COLORADO GEOLOGICAL SURVEY

November 28, 2017

Subject: Springs East at Waterview, Preliminary Plan (SP-17-010)
El Paso County, CO; CGS Unique No. EP-18-0011

KEY MAP

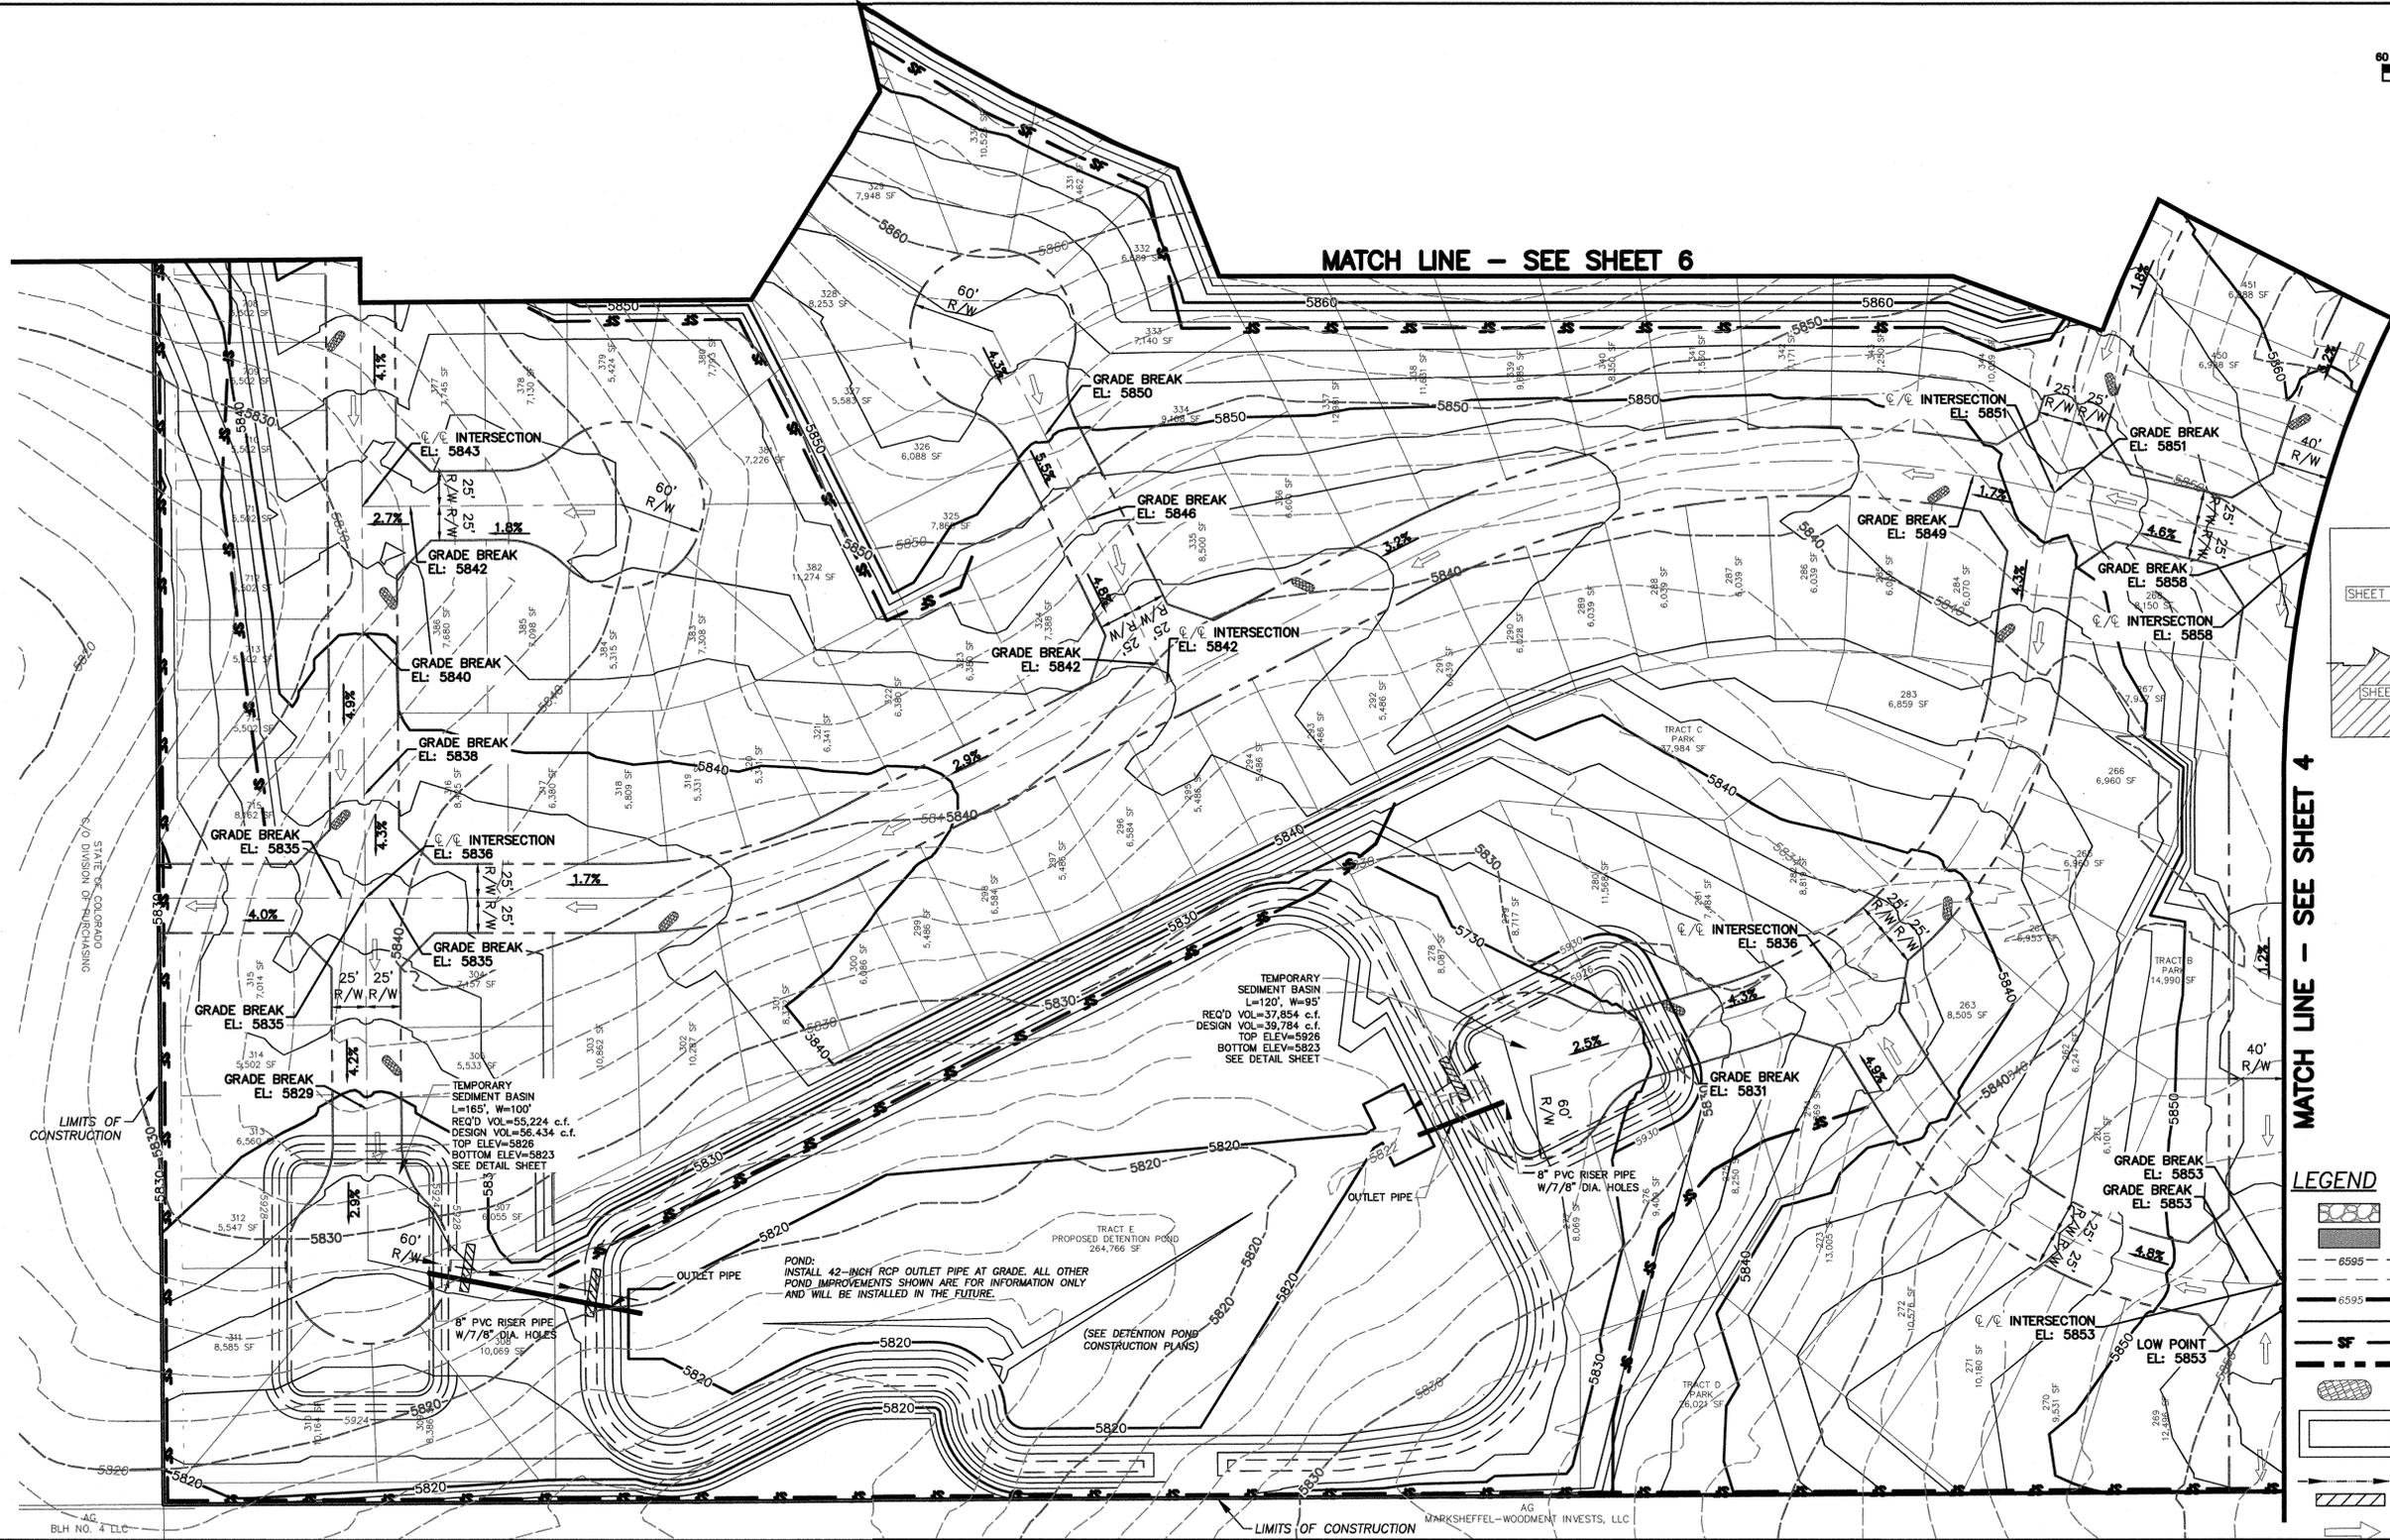
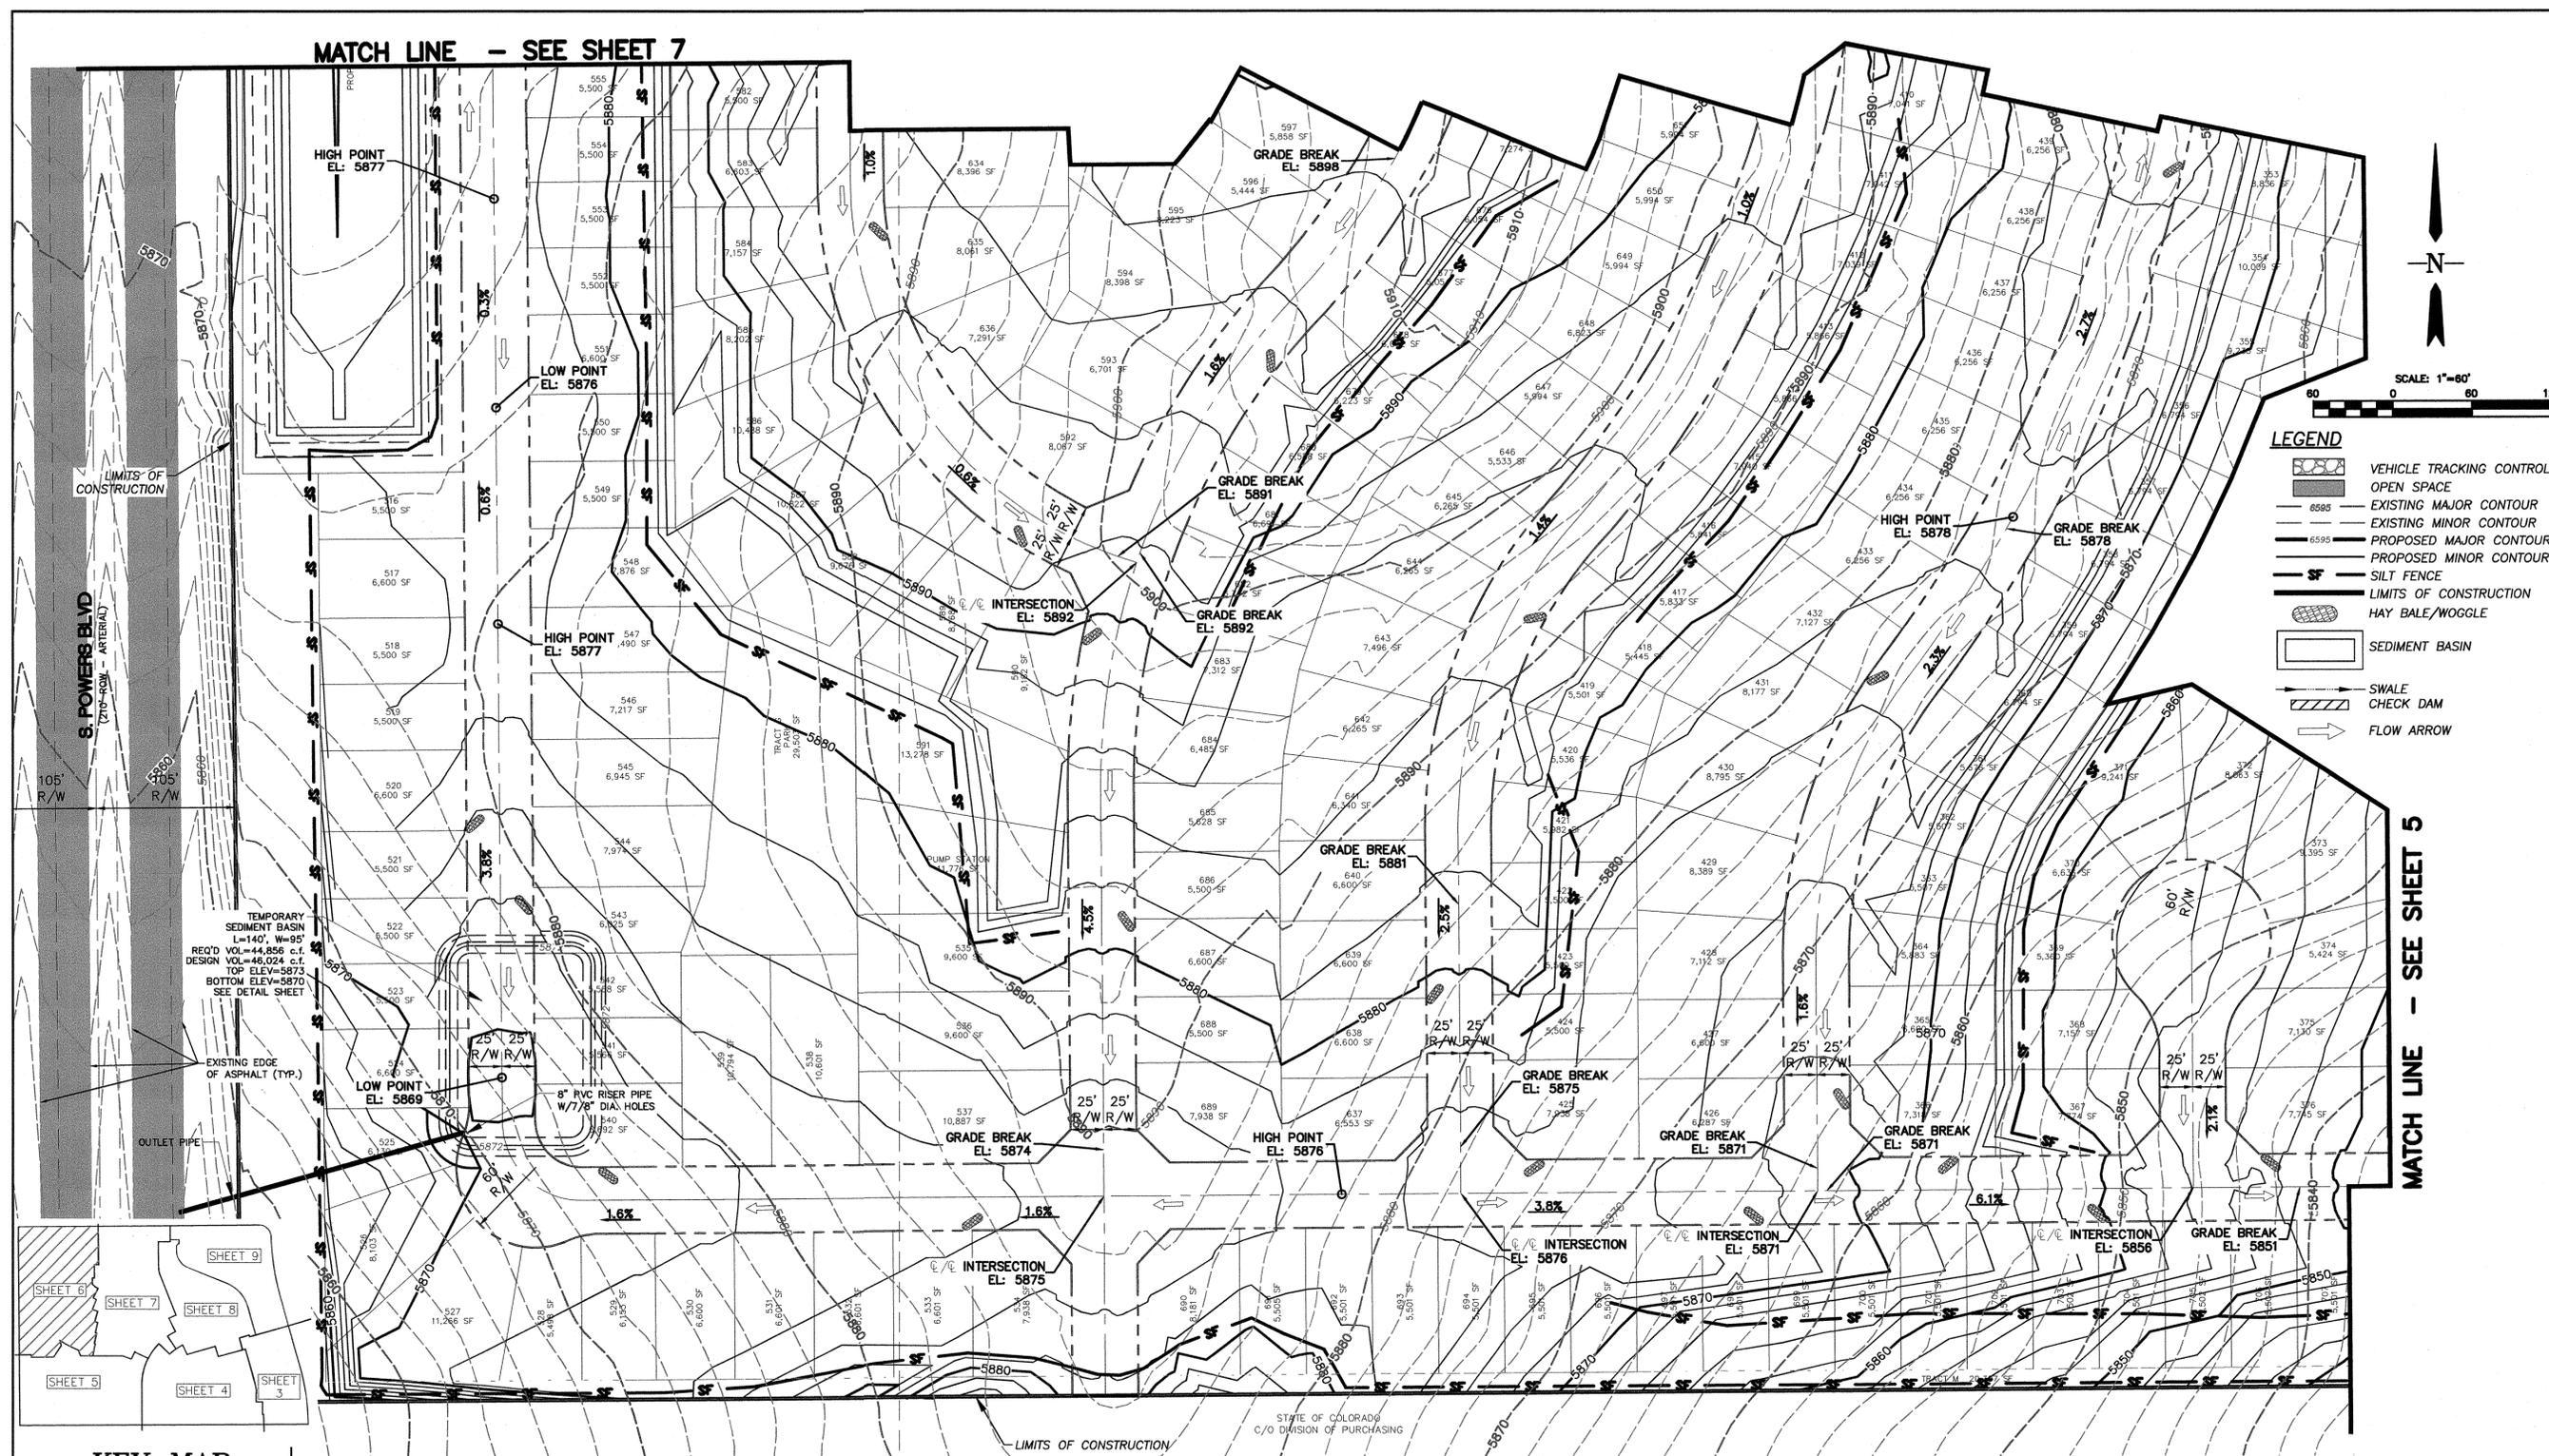
Entech's ten borings were drilled to a depth of 20 feet. The Waterview East Grading and Erosion Control Plan (Stantec, April 3, 2017) indicates that significant cuts and fills are planned, with cuts exceeding 20 feet in some areas. Some of Entech's borings, including but not necessarily limited to TB-1 in the northeastern area of the site, therefore may not extend to sufficient depths to provide meaningful information about soil and bedrock engineering properties and groundwater levels. Additional investigation, sampling, testing and analysis are needed, based on the project grading plans, to characterize subsurface conditions, determine depth and extent of overexcavation, if overexcavation is planned to reduce the use of drilled pier foundations, and to determine basement feasibility in areas of significant cuts where Entech's borings did not extend to sufficient depth below planned basement floor and foundation bearing depths.
